**CITY OF ALBUQUERQUE
PLANNING DEPARTMENT
May 15, 2013
DRB Comments**

ITEM # 9

PROJECT # 1001568

RE: Tracts B & C, Lands of Haddaway

TRACT C-1
0.3118 Ac. GROSS
0.2529 Ac. NET

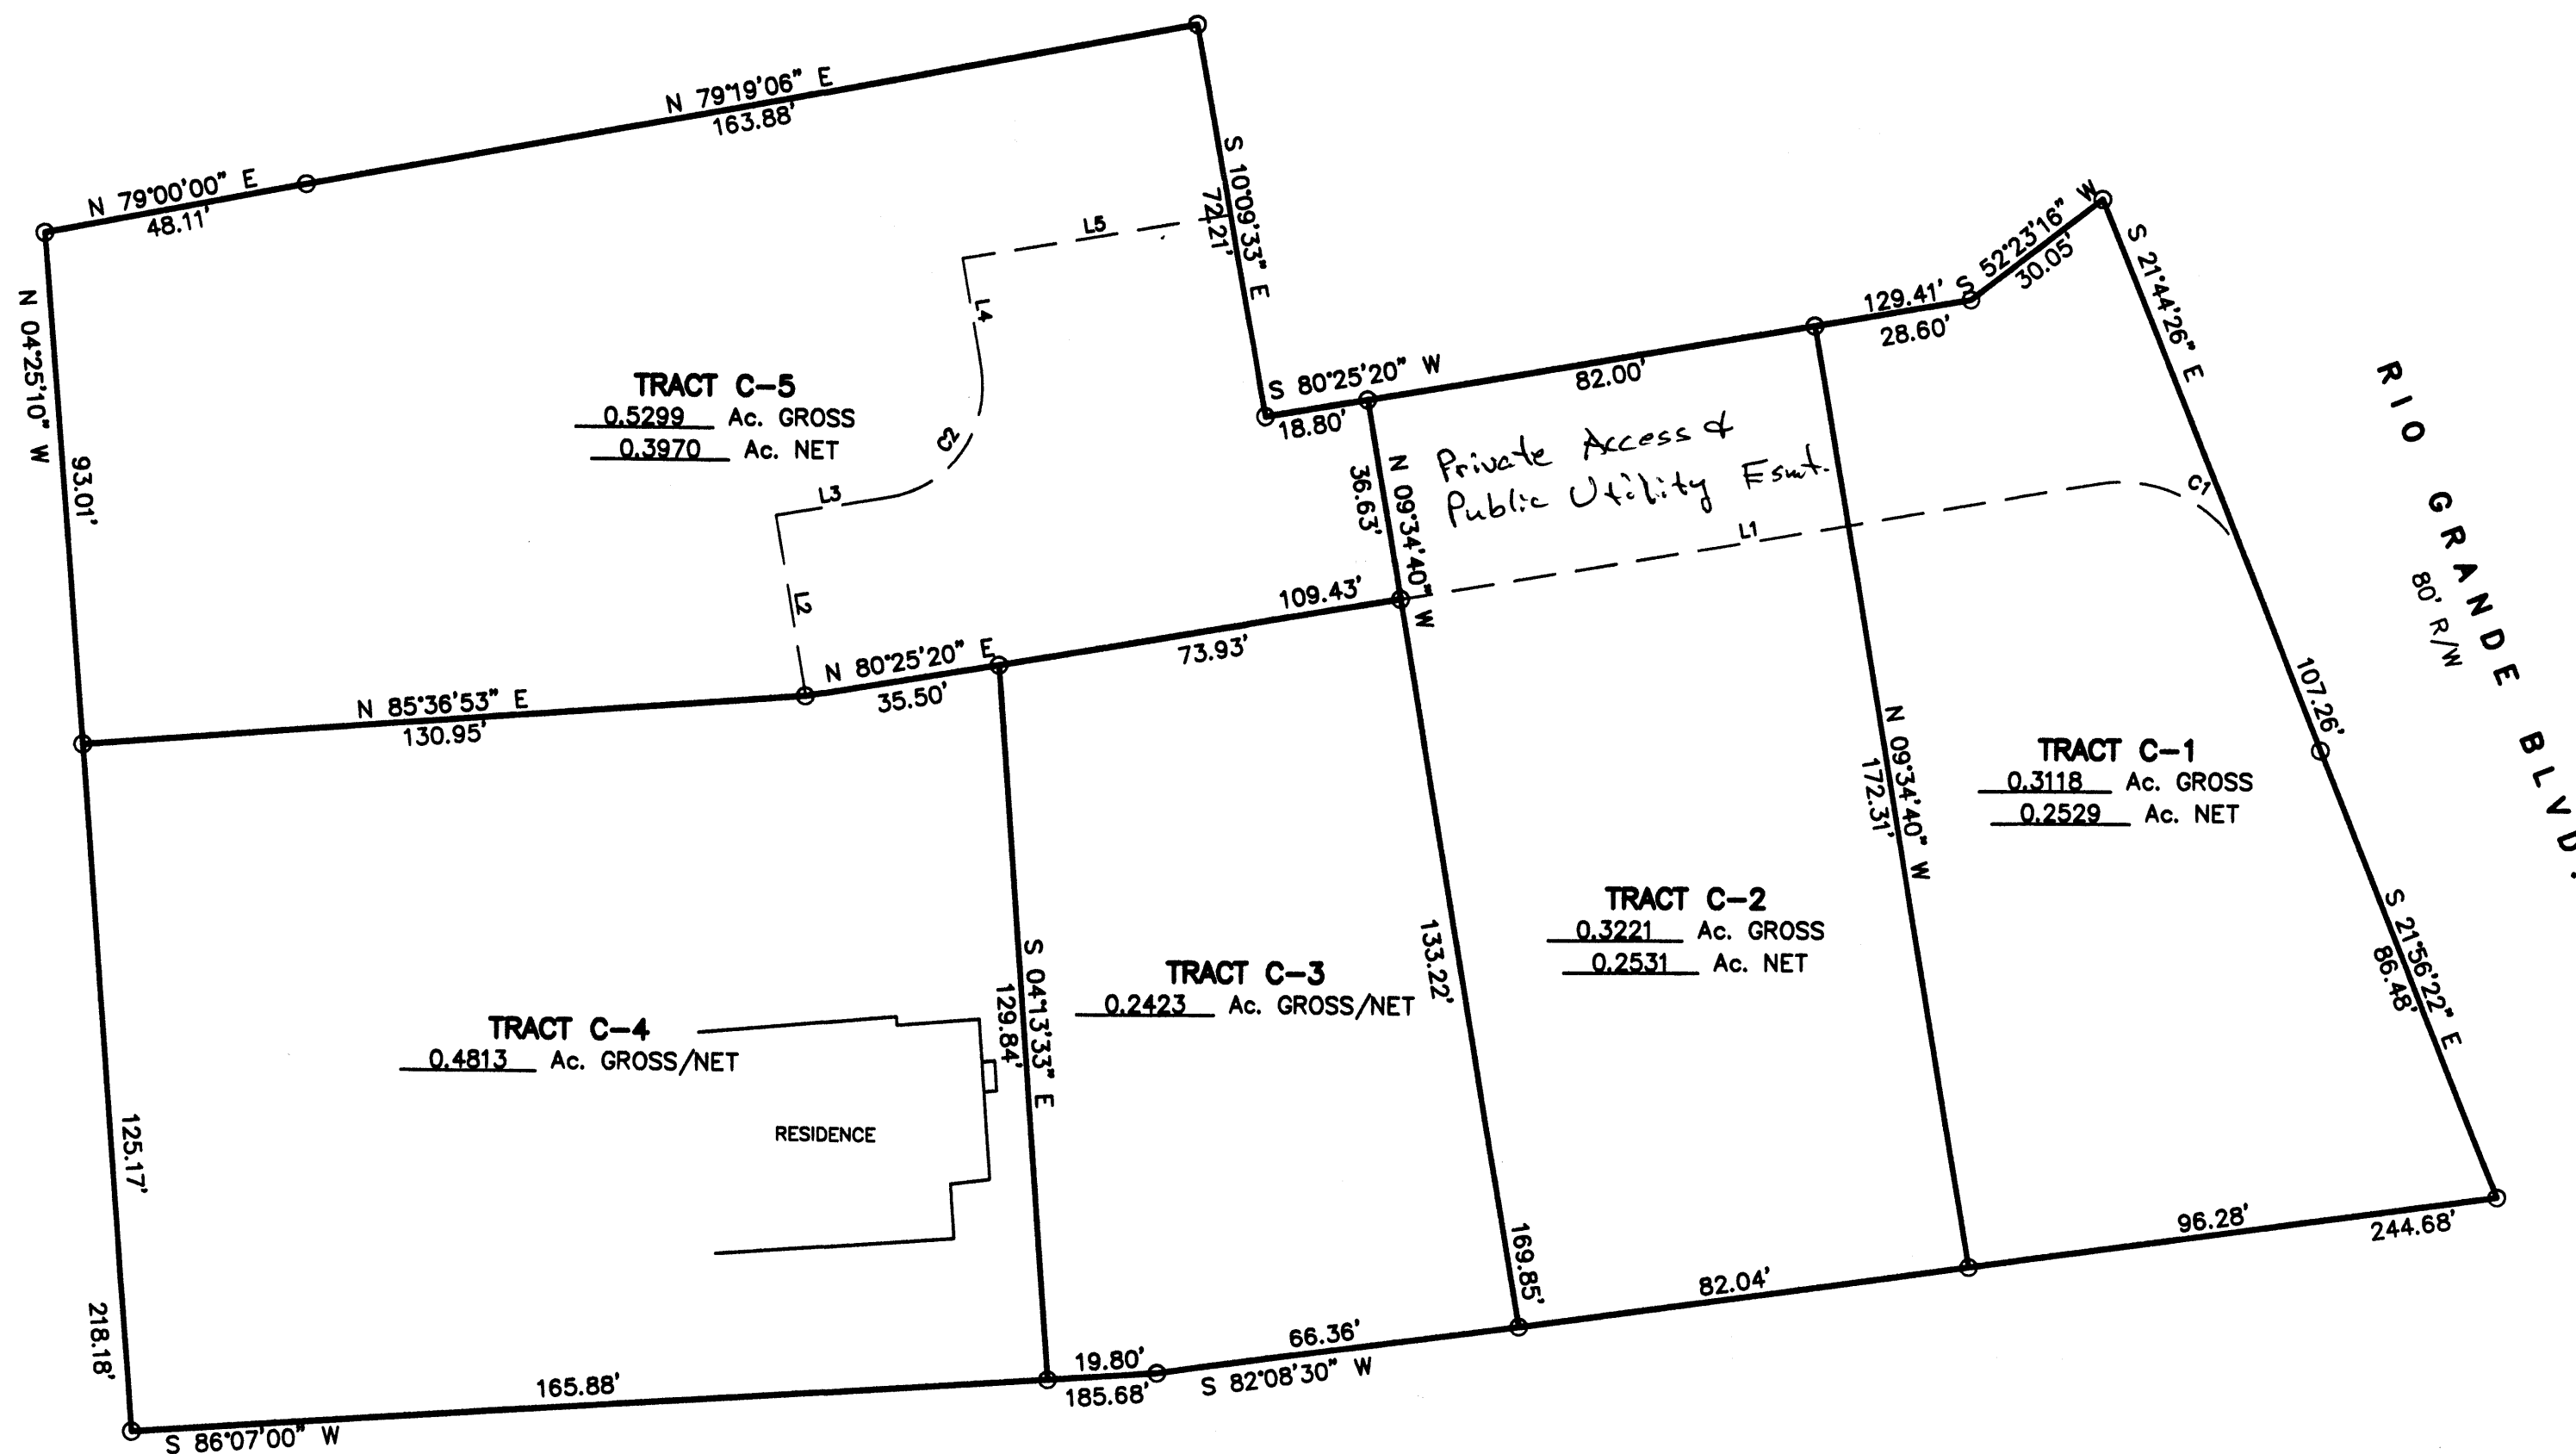
The existing lot line defines the zone boundary for this area – a zone change is needed, so the lot line would define a new zone boundary.

Maintenance and beneficiaries of proposed easement must be specified on the plat. Future development of proposed Tract C-2 will be restricted to what is allowed by the proposed easement, e.g. if it does not include an easement for public water and sewer lines then there could be no further development without obtaining such an easement over the tract on Rio Grande Blvd.

SKETCH PLAT
 TRACTS C-1, C-2 AND C-3
 LANDS OF HADDAWAY
 CITY OF ALBUQUERQUE
 BERNALILLO COUNTY, NEW MEXICO
 JULY, 2012

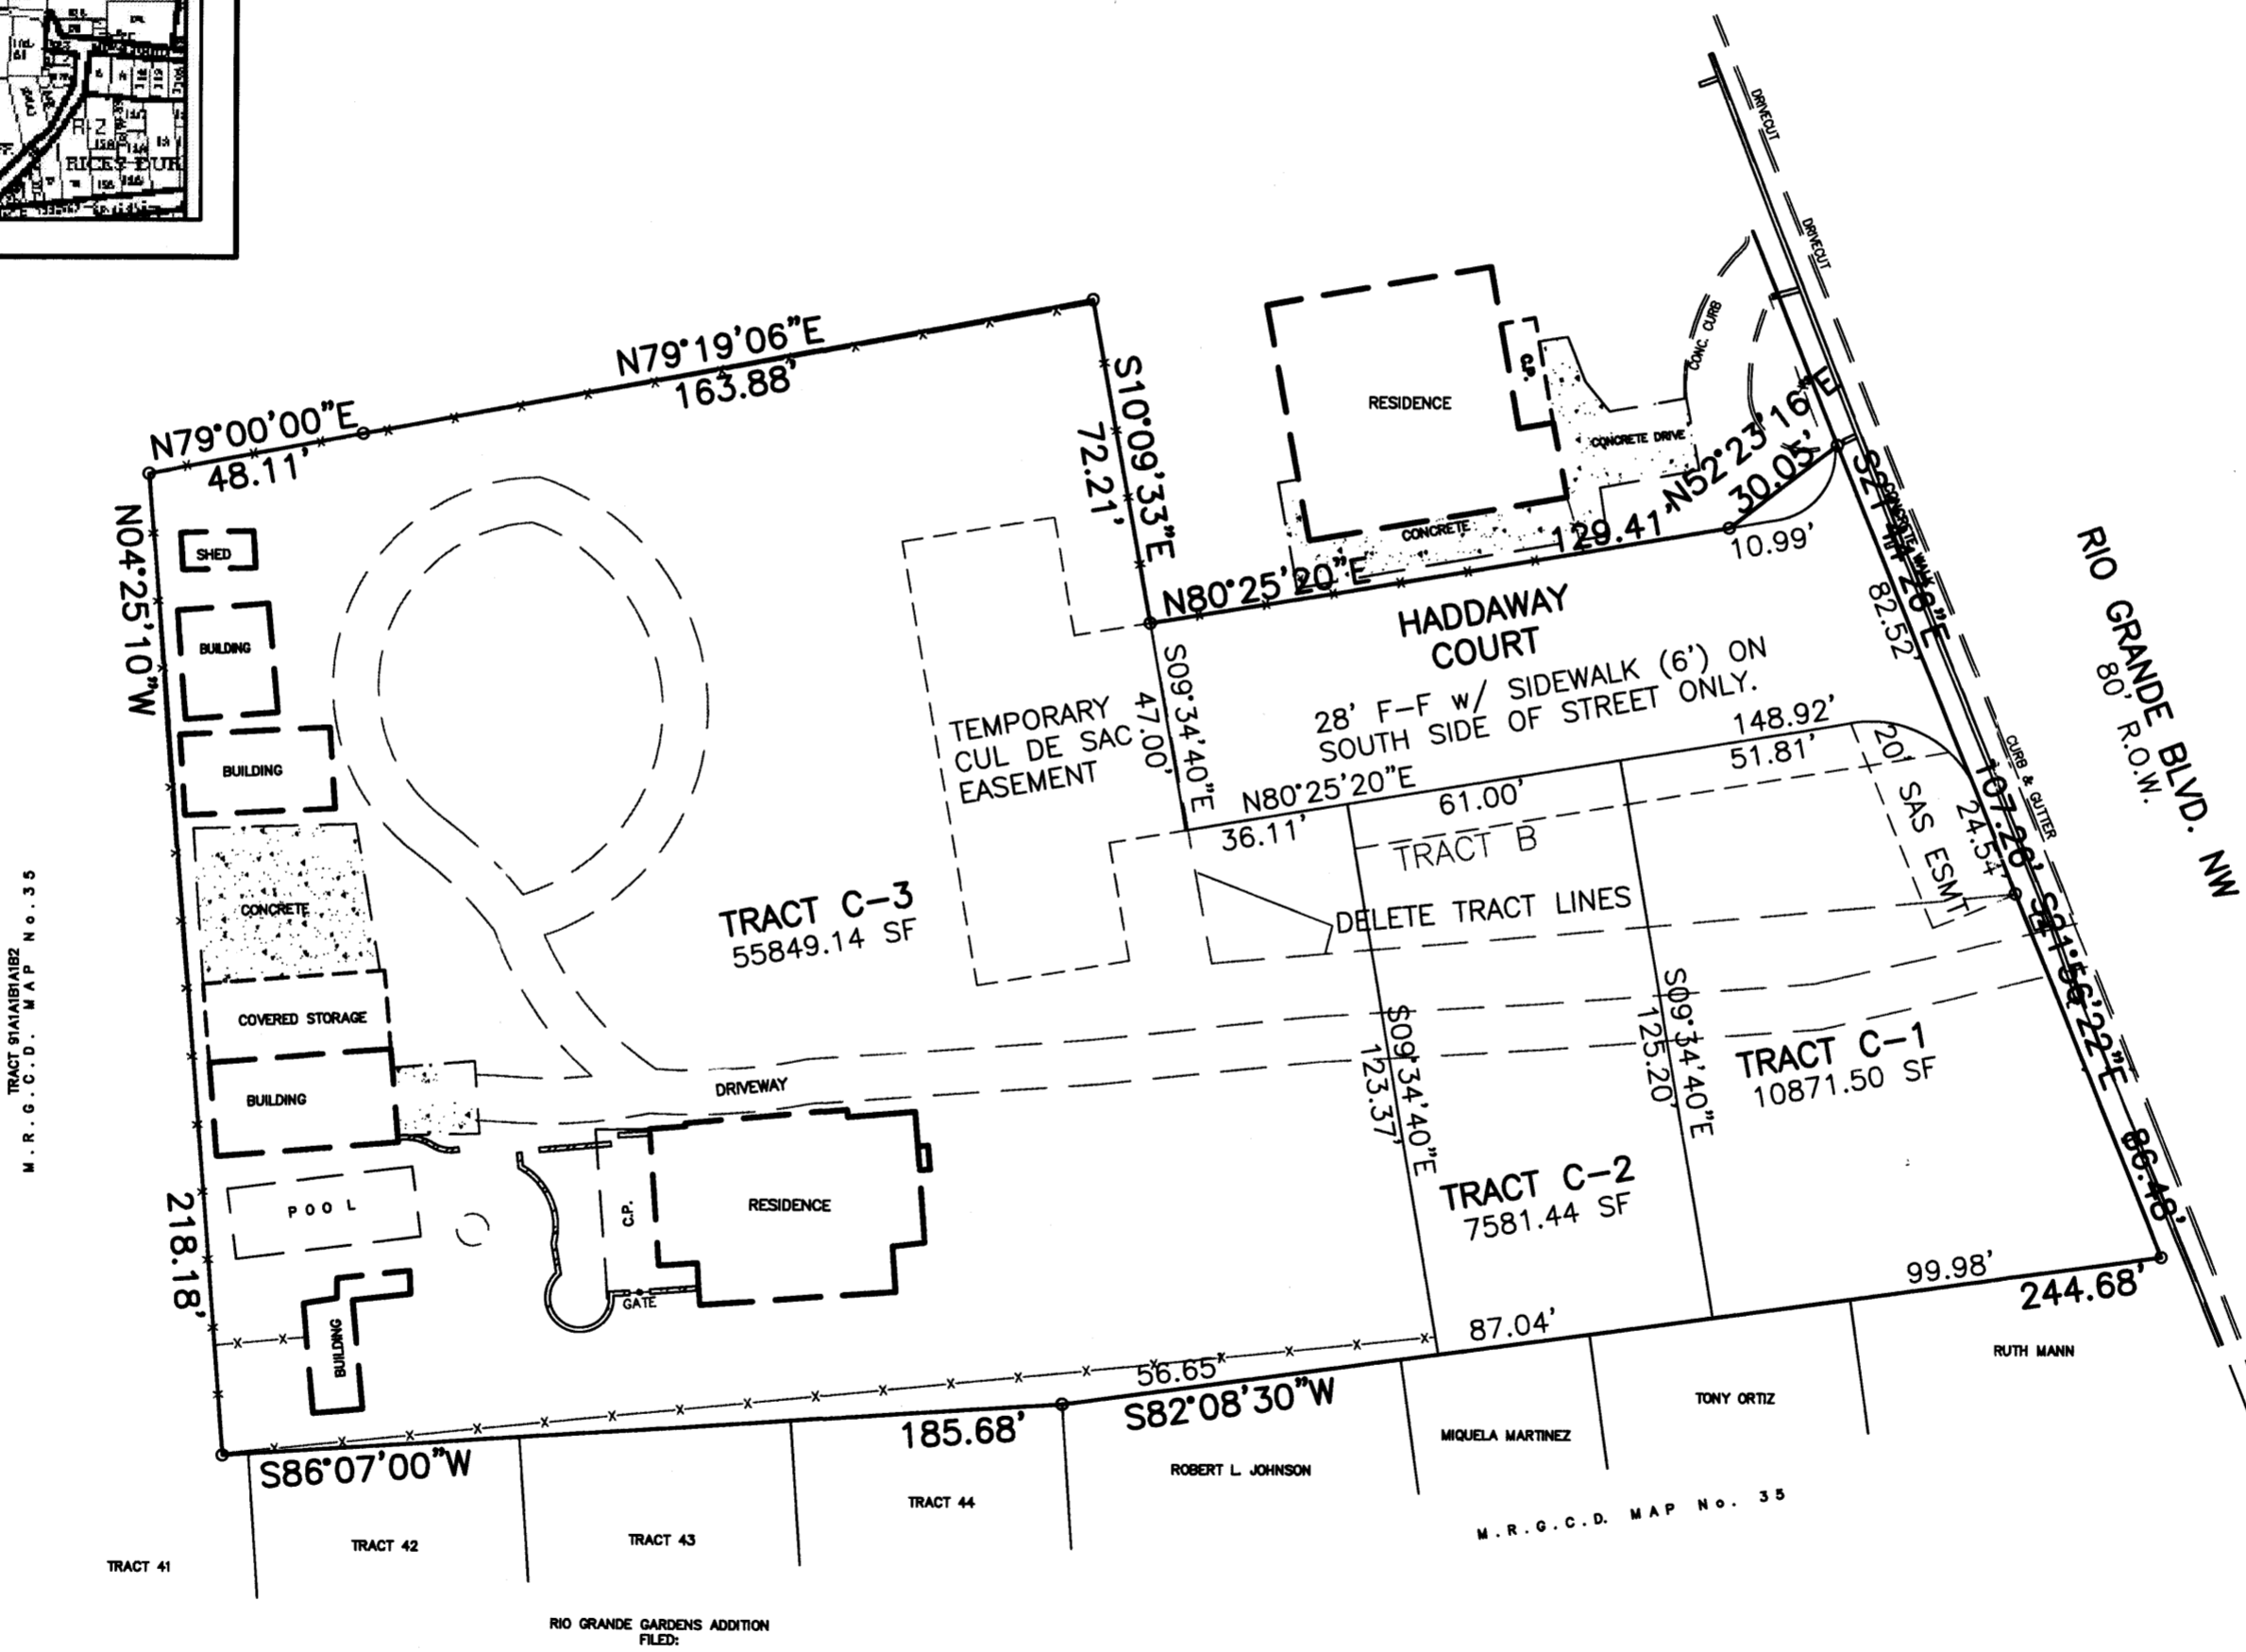
Please provide correct scale for Sketch Plat and Exhibit Tract C (1"=40'). Zoning for the site is established via the Los Duranes Sector Development Plan whereby Tract C is SU-2/ LD RA-2 (minimum 10,890 sq ft net lot area) and Tract B is SU-2/ LD R-1 (minimum 10,890 sq ft net lot area); proposed subdivision would require a Sector Plan and Zone Map amendment. The site is also subject to the Rio Grande Boulevard Corridor Plan, which has additional design regulations as well as policy and regulations for rezoning.

Private access easement should not be a separate tract but should be an overlay over all the properties. The access off Rio Grande should be considered to be at the south property line, to run adjacent to the rear yards on Zickart not adjacent to the side yard and curb cut on Tract A.

A Private Commons Development (PCD) is permissible through the Los Duranes Plan, whereby equivalent RA-2 density would be allowed (total 6 dwellings) subject to providing a private common area equal to a minimum 20,909 sq ft (30% of gross area) or 100% of the area gained thru lot size reduction (e.g, from 6 townhouses), whichever is greater.
